Metro, Kristal D.

Re: Discount Tire Additional Parking Lot - Lot 19, Menaul Blvd / Florida St NE,
Traffic Circulation Layout
Engineer's Stamp dated 05-28-09 (H18-D036)

**Re: Discount Tire Additional Parking - Lot 19, Menaul Blvd / Florida St NE,
Traffic Circulation Layout
Engineer's Stamp dated 05-06-09 (H18-D036)**

DISCOUNT TIRE, MENAUL BLVD AND FLORIDA ST	DRAWN BY DY
	TRAFFIC CIRCULATION LAYOUT	DATE 05/28/09
TIERRA WEST, LLC 5571 MIDWAY PARK PLACE NE ALBUQUERQUE, NM 87109 (505)858-3100	28108-SH02-TCL	SHEET # 2
RONALD R. BOHANNAN P.E. #7868	JOB # 28108

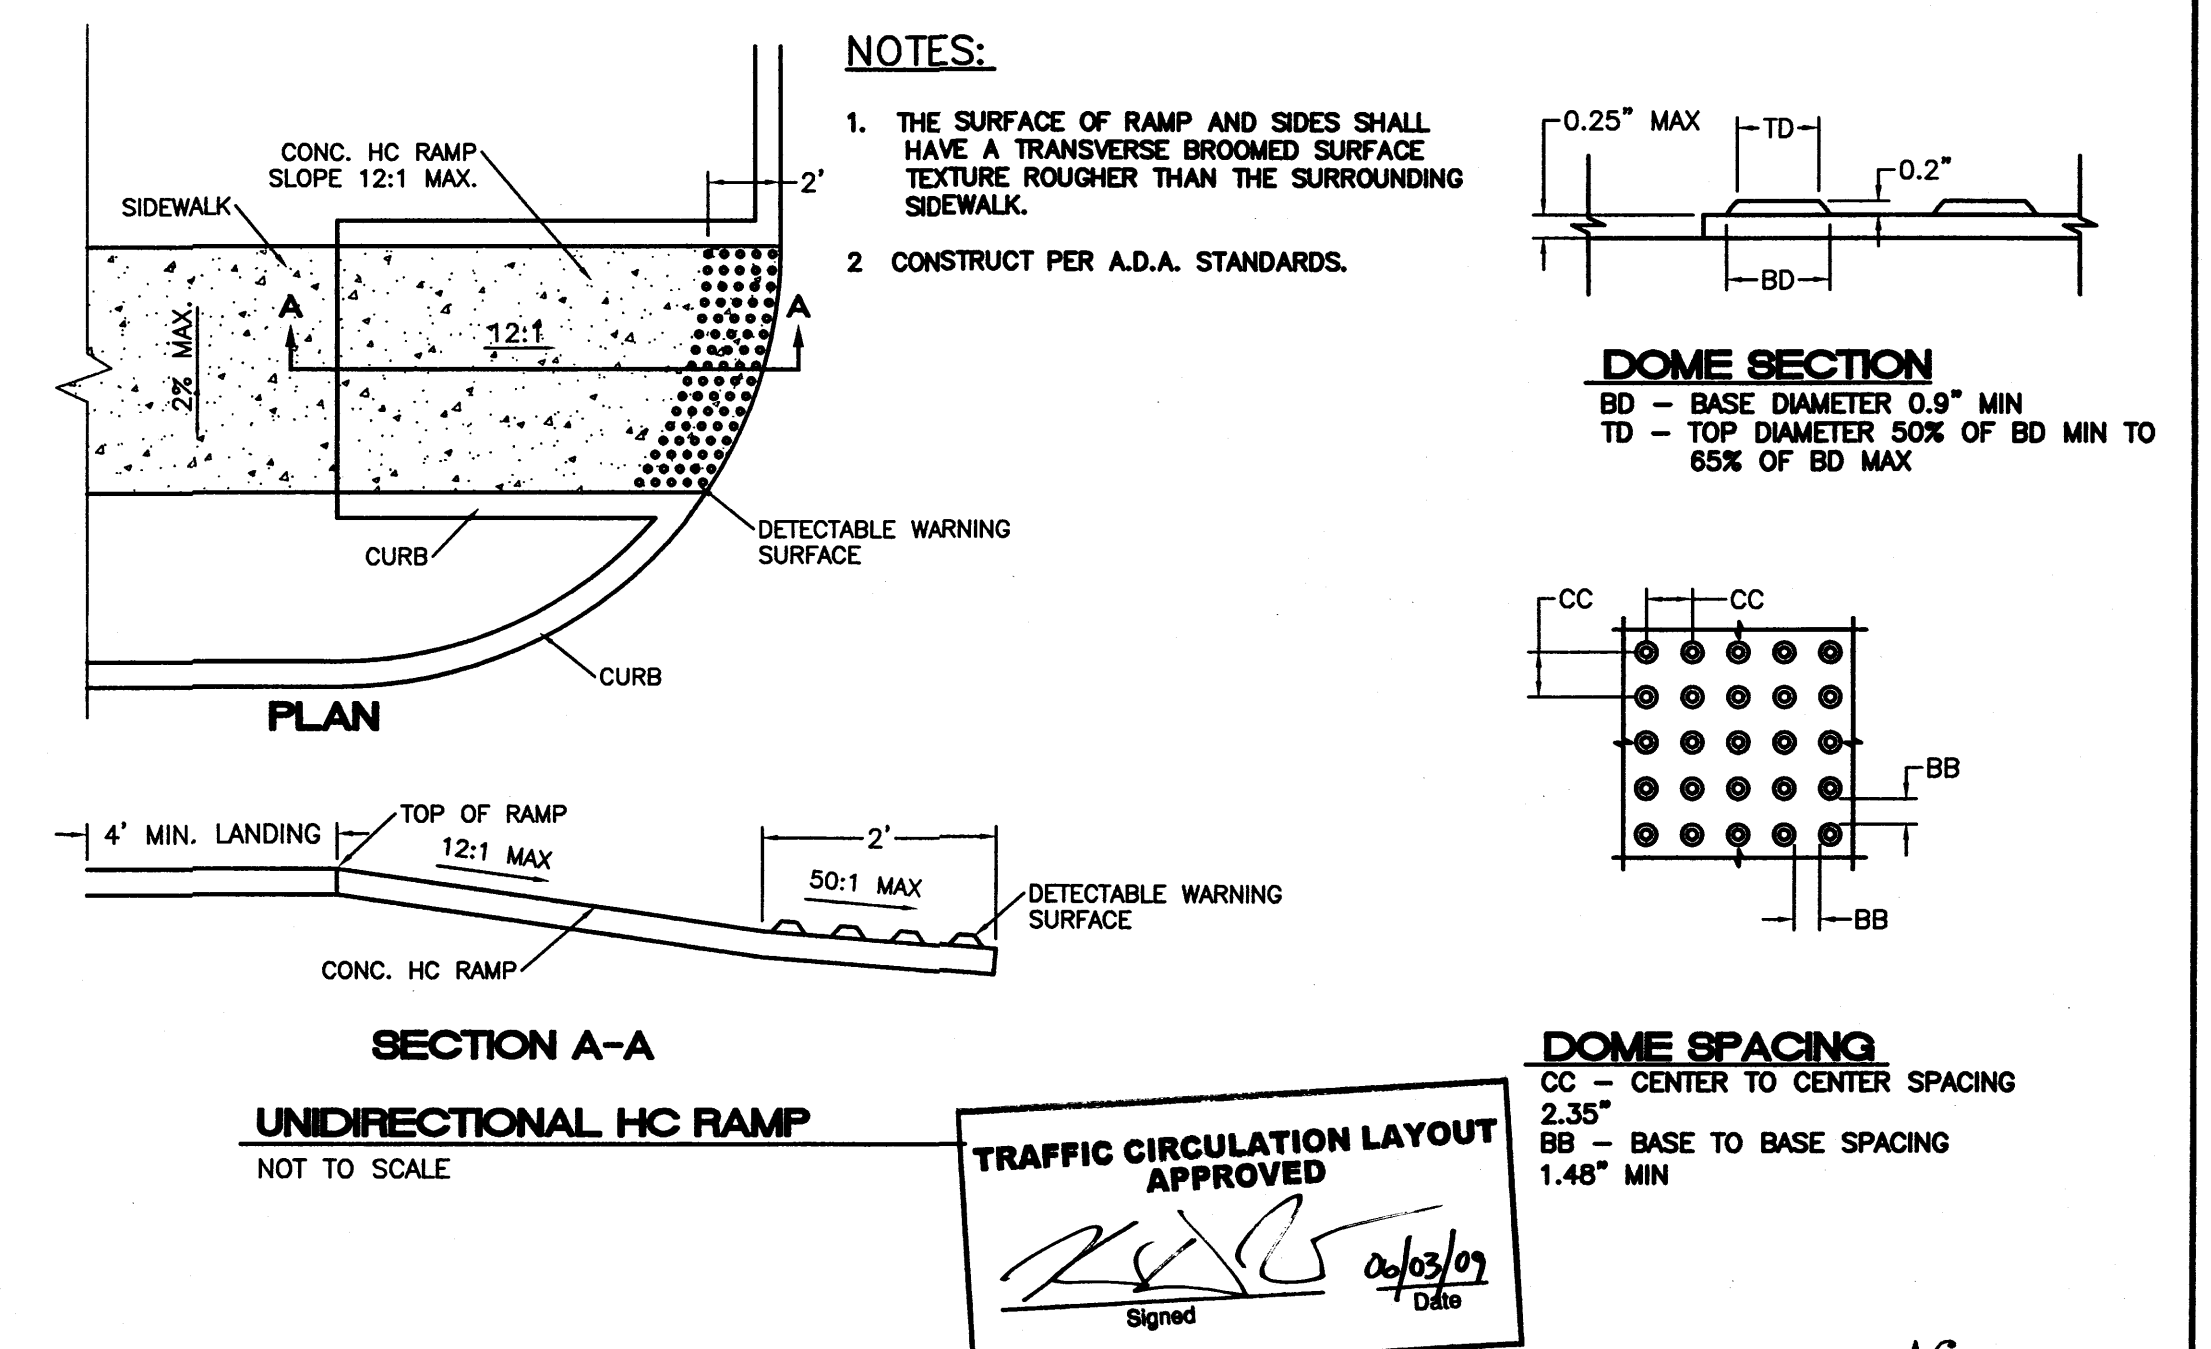
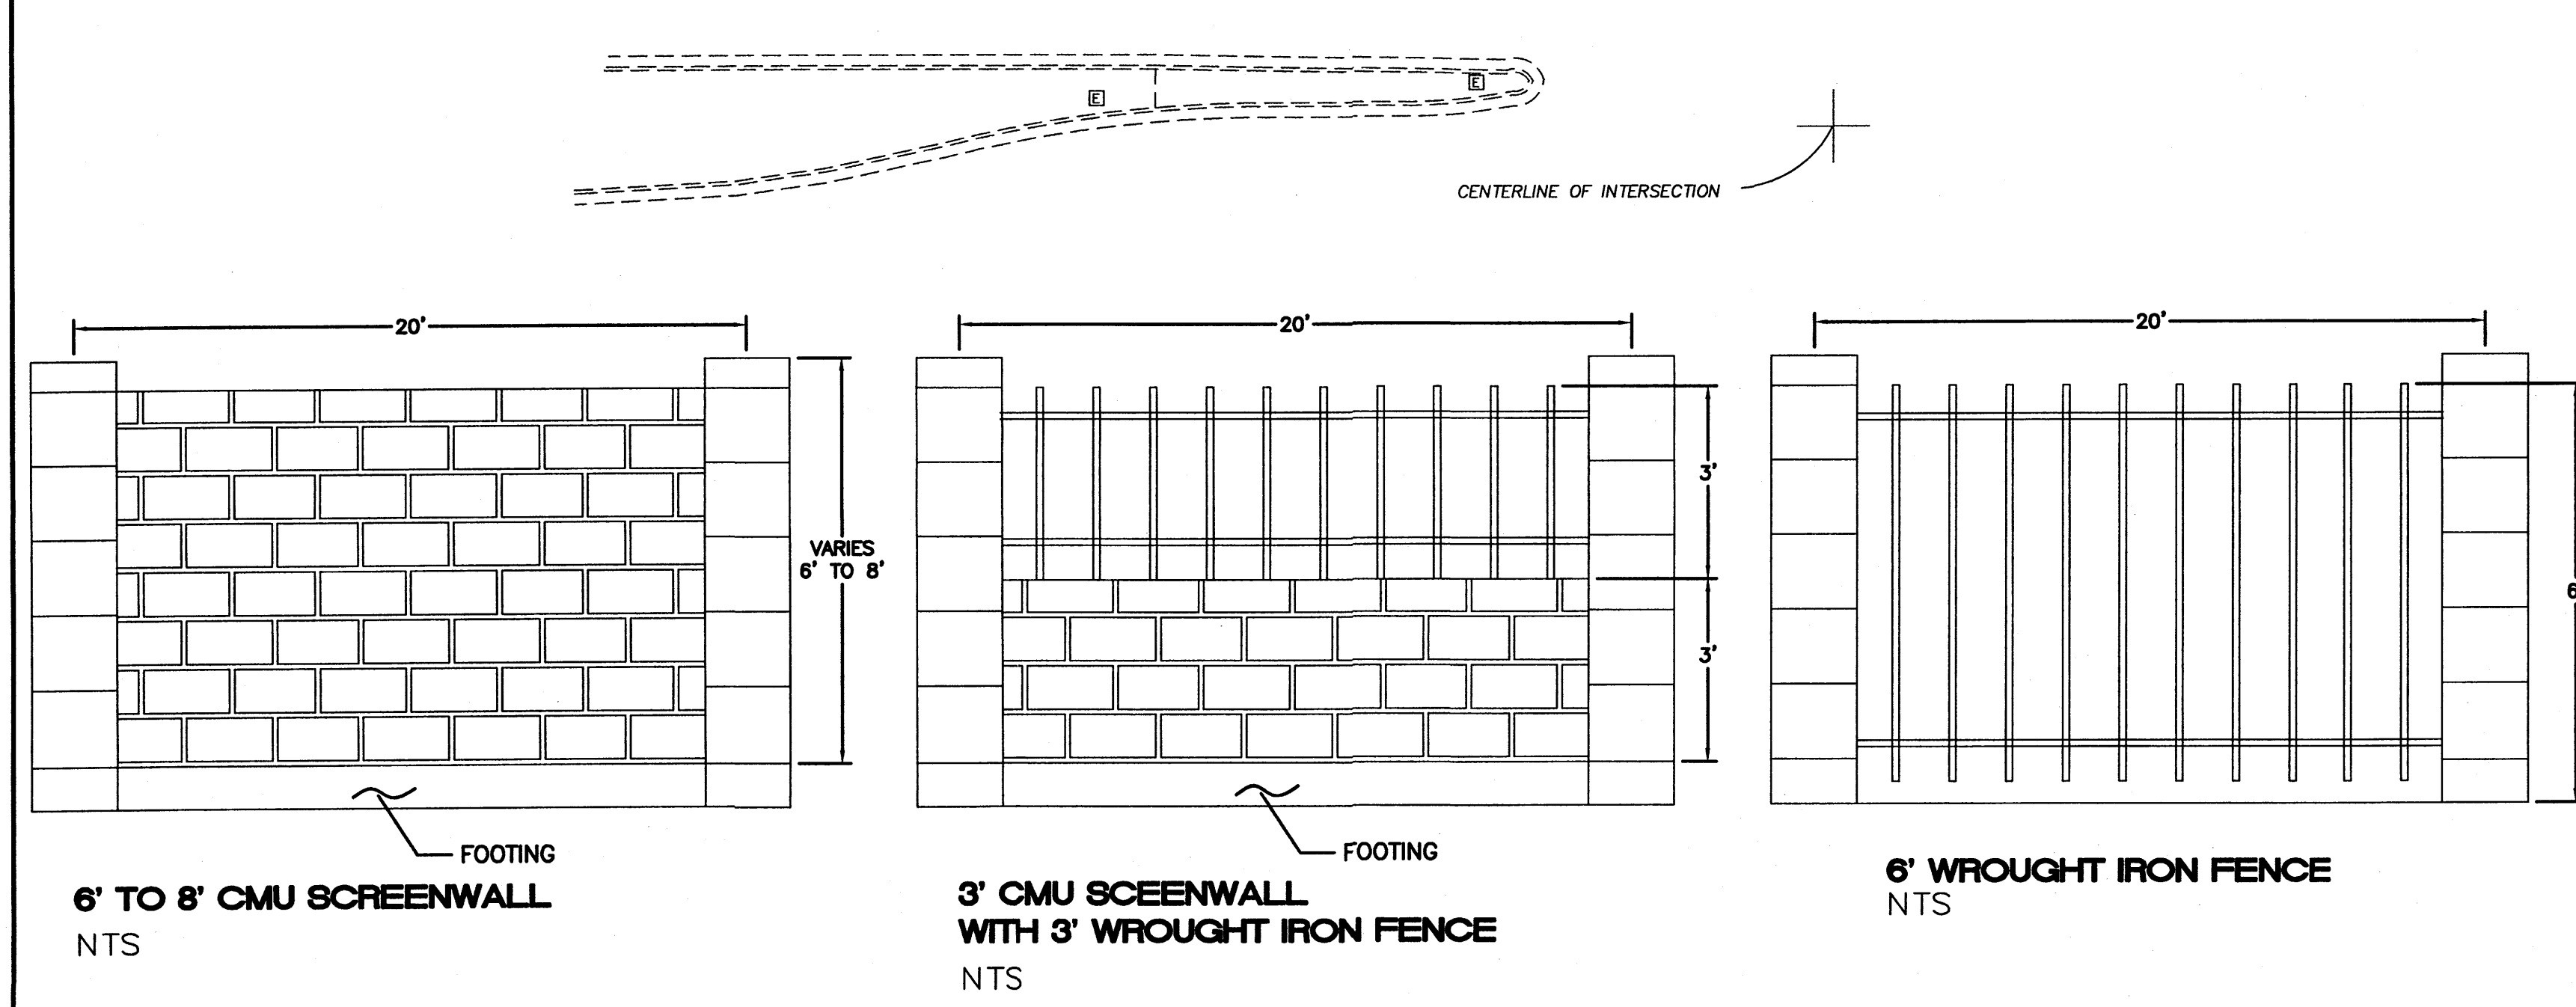
I have attached a copy of the TCL you approved for the construction of the new parking lot for the Discount Tire on Florida Street, off Menaul. The issue of access for dropping of cars that are brought in on tow trucks came up this week. Discount Tire would now like to have the existing drive off Florida left in place. We had shown this drive to be removed. I told them I would ask the question. What do you think?

Vince, Discount Tire wants to leave the North drive approach, on Florida, to the parking lot. Can we do that, or is it a city requirement to get rid of it? Thanks, Scot

1. For passenger vehicles, the minimum end island radius is 15 feet. The five-foot radius at the entrance and exit is not acceptable; a drivepad is suggested.
- ~~2. A five-foot keyway is required for deadend parking aisles.~~
3. Is this plan intended for work within lots 4 and 5 in addition to lot 19? If so, additional geometric information must be provided for lots 4 and 5.
- ~~4. Please list the width and length for all parking spaces.~~
5. Label the compact parking spaces by placing the words "compact" on the pavement of each space.
